**Sent:** 19 September 2012 17:04  
**To:** Planning  
**Subject:** Planning application S6/2012/1635/FP - Twelve Apostles Church

**Response to Planning application from Hertfordshire County Council (T and CP GDP Order 1995)**

**Location**  
 Twelve Apostles Church  
 Kentish Lane  
 Brookmans Park  
 Hatfield

**Proposal**  
 Retention of change of Use of land to create extension to existing car park and associated landscaping.

PROPOSED PLAN

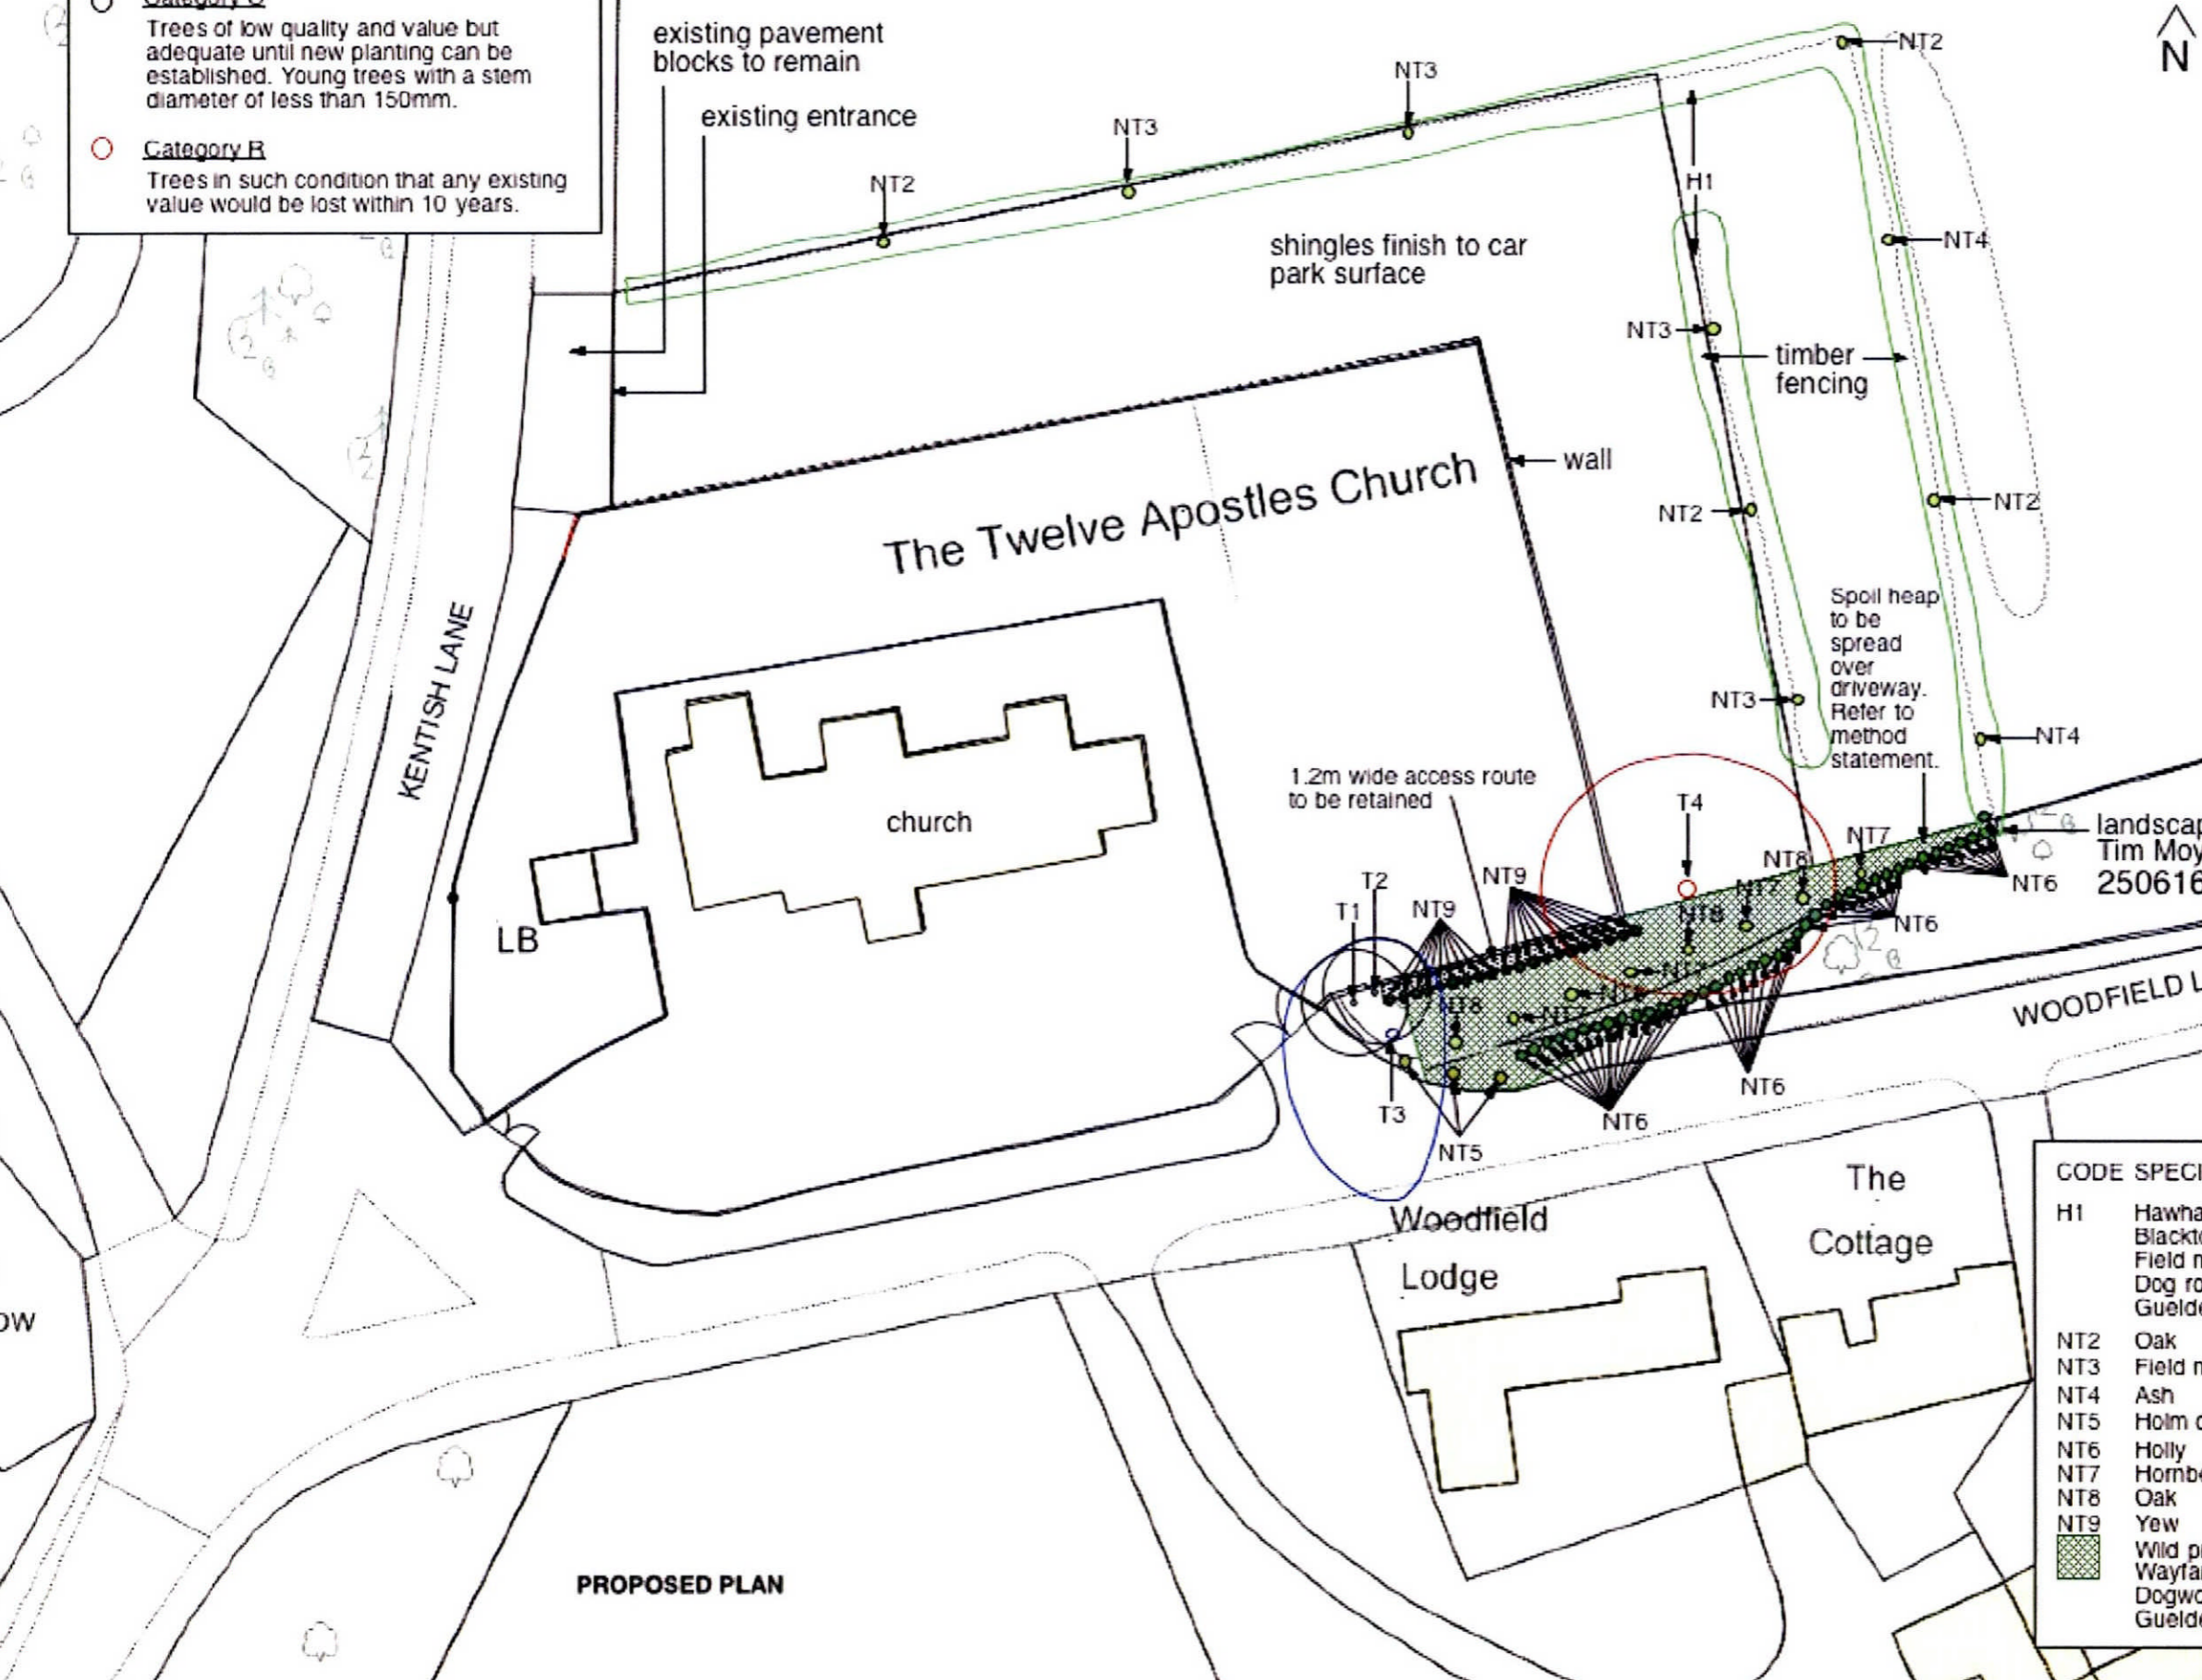
1. Before first occupation of the approved development, the existing access onto Kentish Lane shall be reconstructed in accordance with the approved in principle plans and constructed to the specification of the Highway Authority and Local Planning Authority's satisfaction.

2. C.8.10 -Any gates to be provided shall be set back a minimum of 6.0m from the edge of carriageway and shall open inwards into the site.

3. C8.13 - No unbound material shall be used on the proposed access within 6 metres of the highway boundary. Details of the proposed surface dressing shall be submitted to and agreed in writing by the local planning authority, prior to the commencement of the development and implemented in accordance with those details
